Our ref: DOC22/366094

Your ref: SSD-13855453

**Grenfell Poultry Breeder Farm – Response to Submissions**

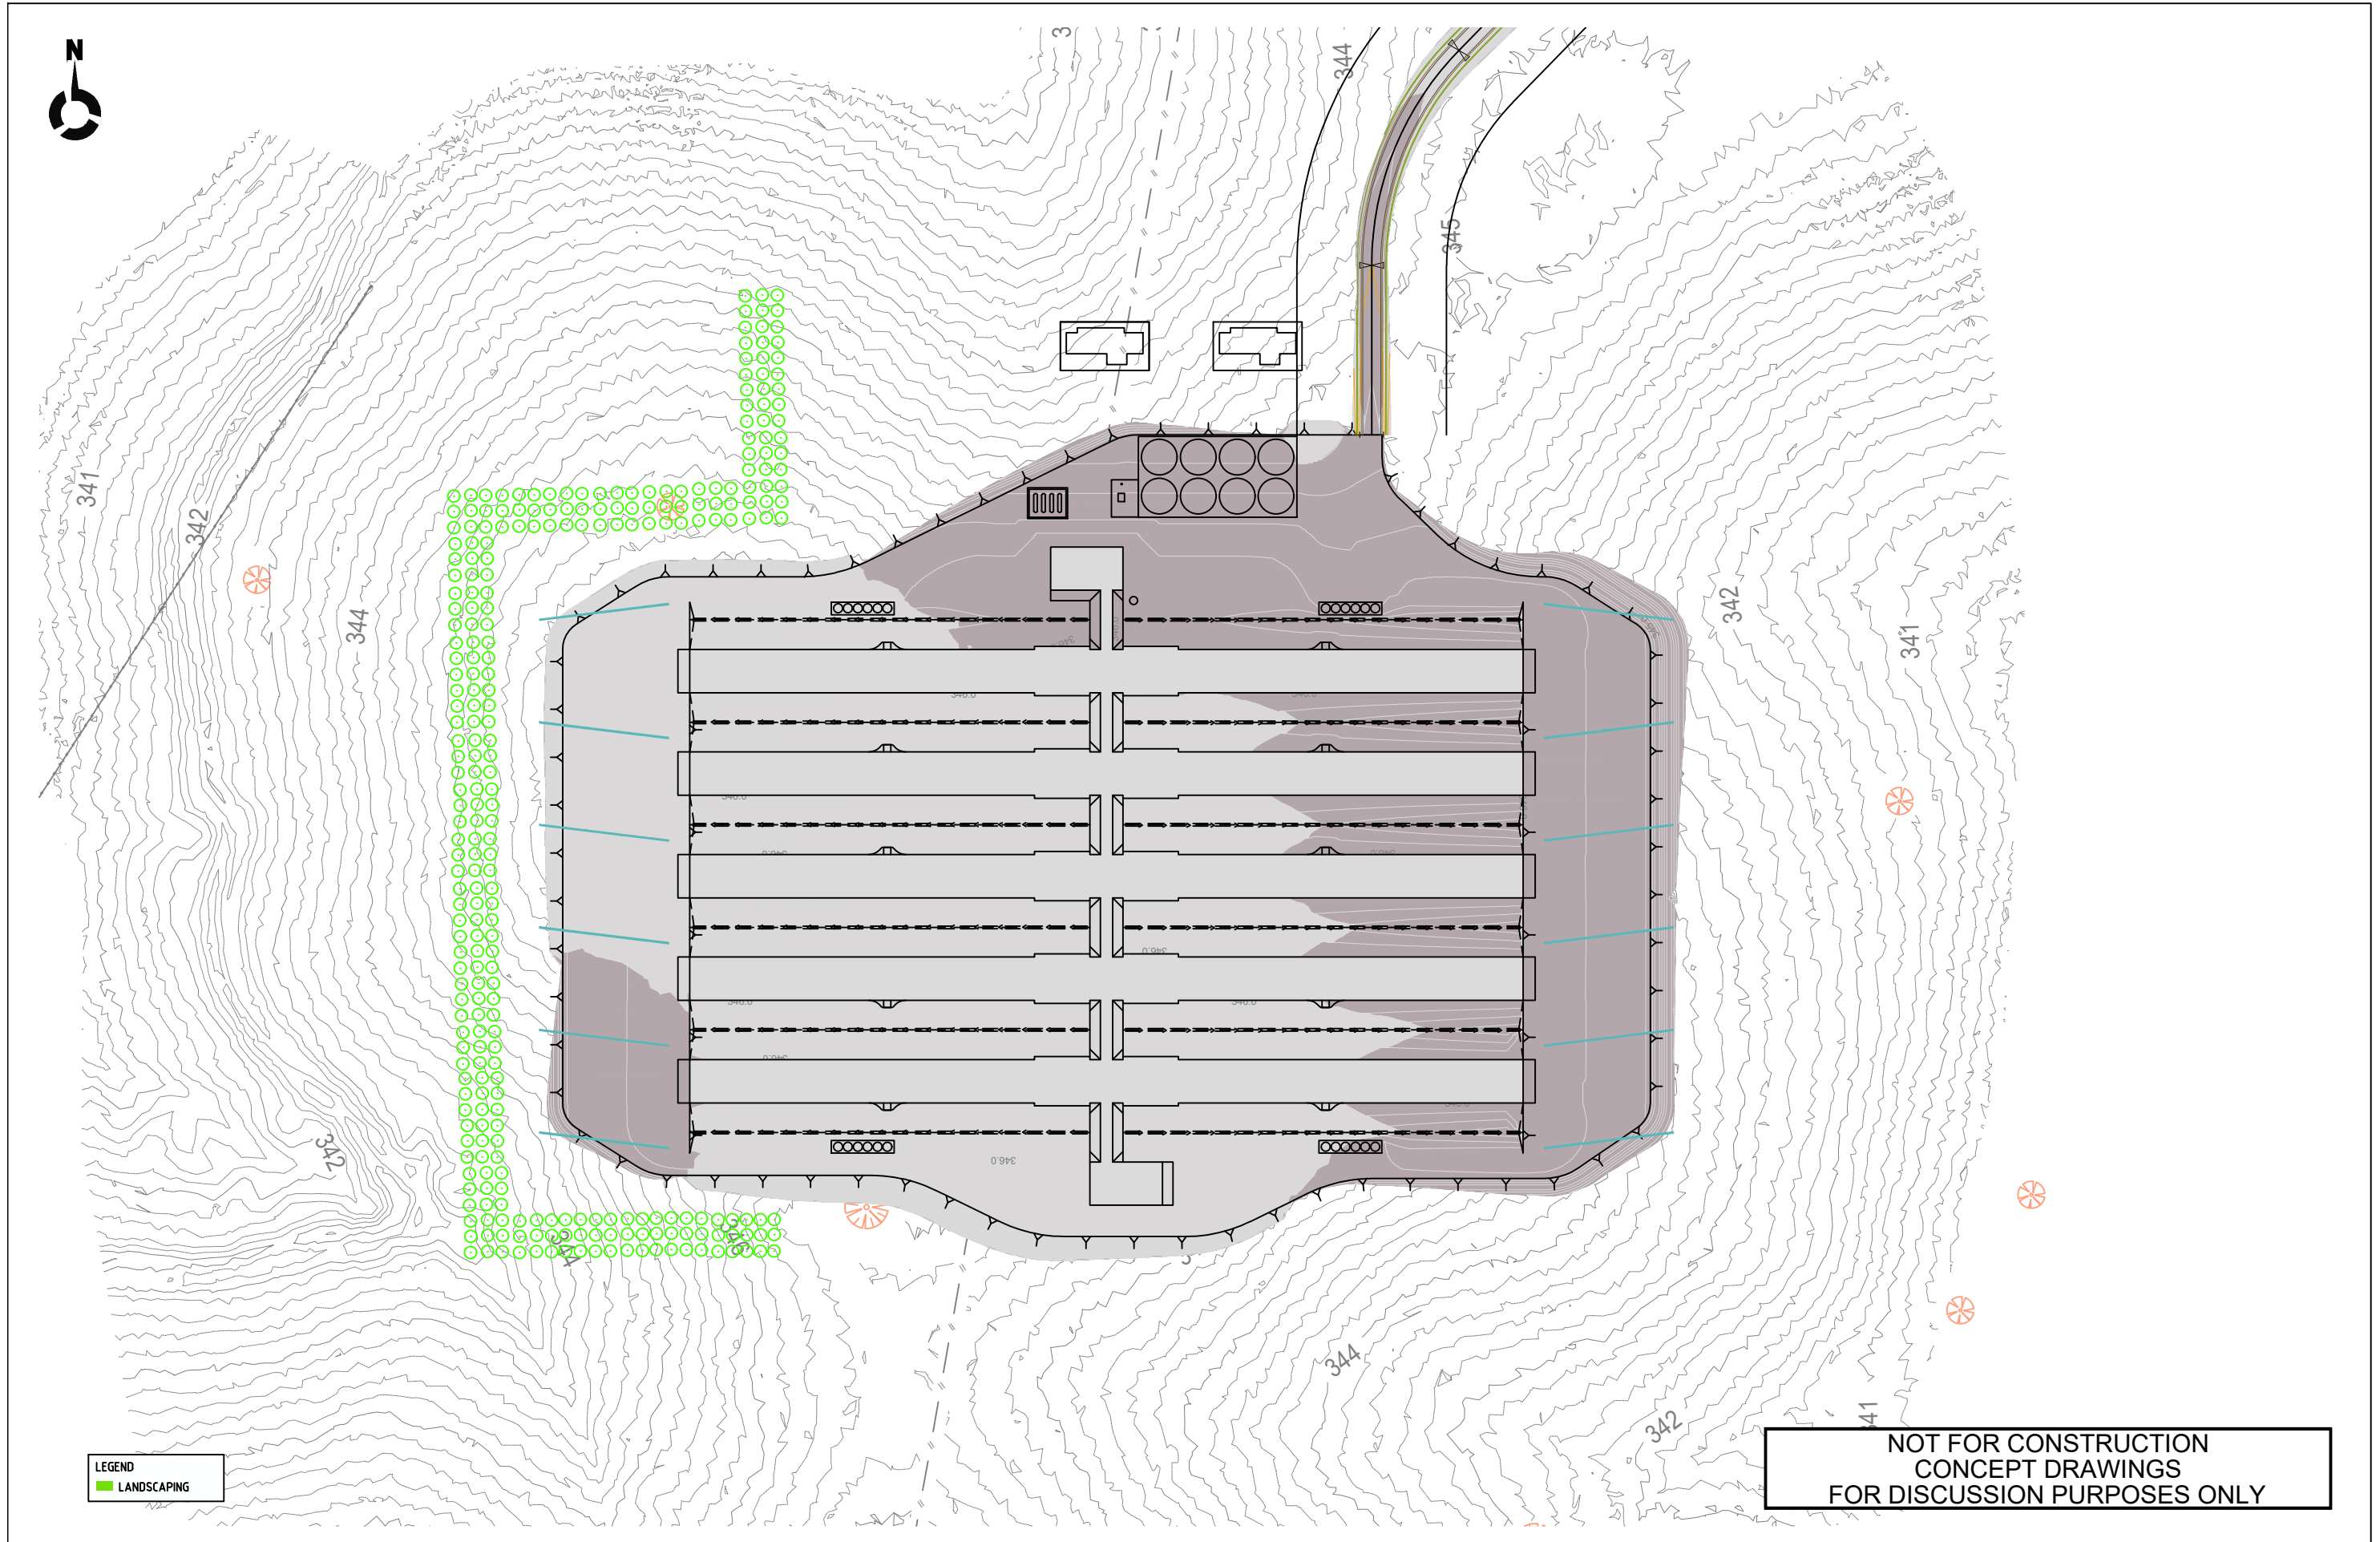
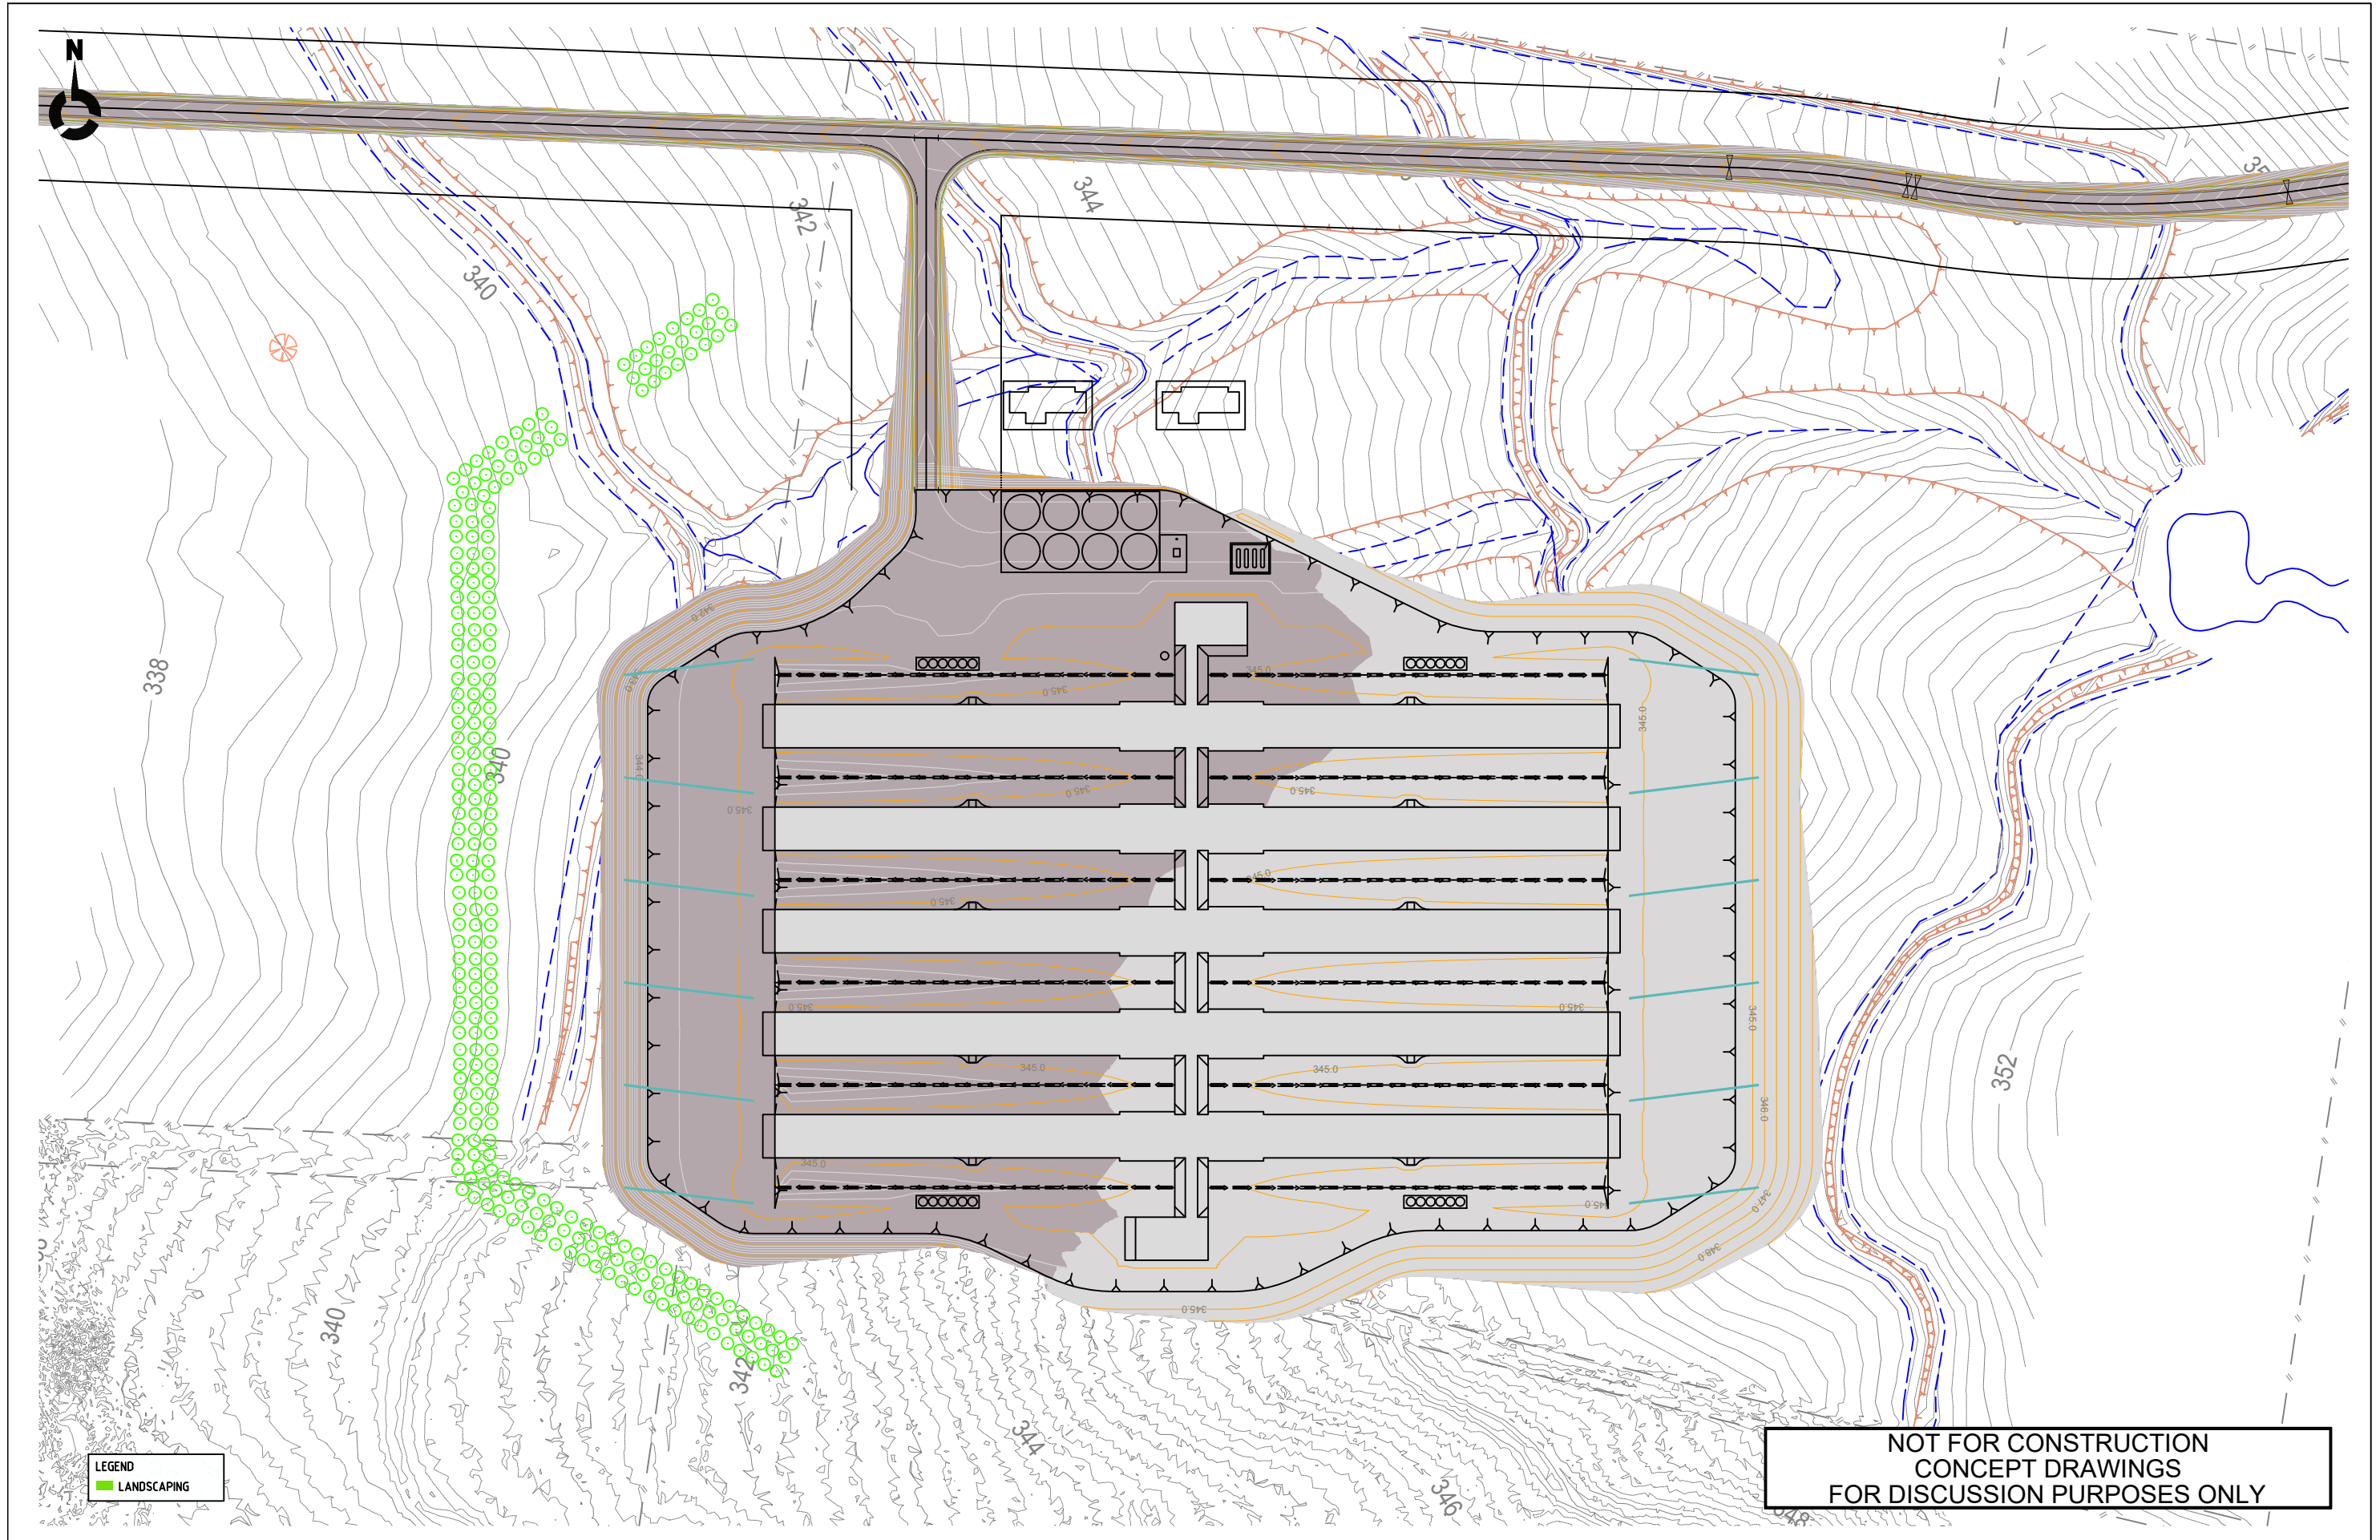
The updated concept plan for the project site submitted by the proponent includes a 25m road buffer and road widening within the site entry point from Gooloogong Road. BCS notes from review of the concept plan that these design changes may require additional clearing of biodiversity values which have not been included within the Biodiversity Development Assessment Report (BDAR) or the projects associated offset calculations.

BCS recommends that both the BDAR and the projects offset calculations are updated to include the abovementioned project design changes. If the total clearing required for the proposed design changes are conceptual and/or uncertain at this point in time, BCS recommends that the upper quantum of vegetation clearing required for the project is assessed and calculated, according to a worst-case scenario.
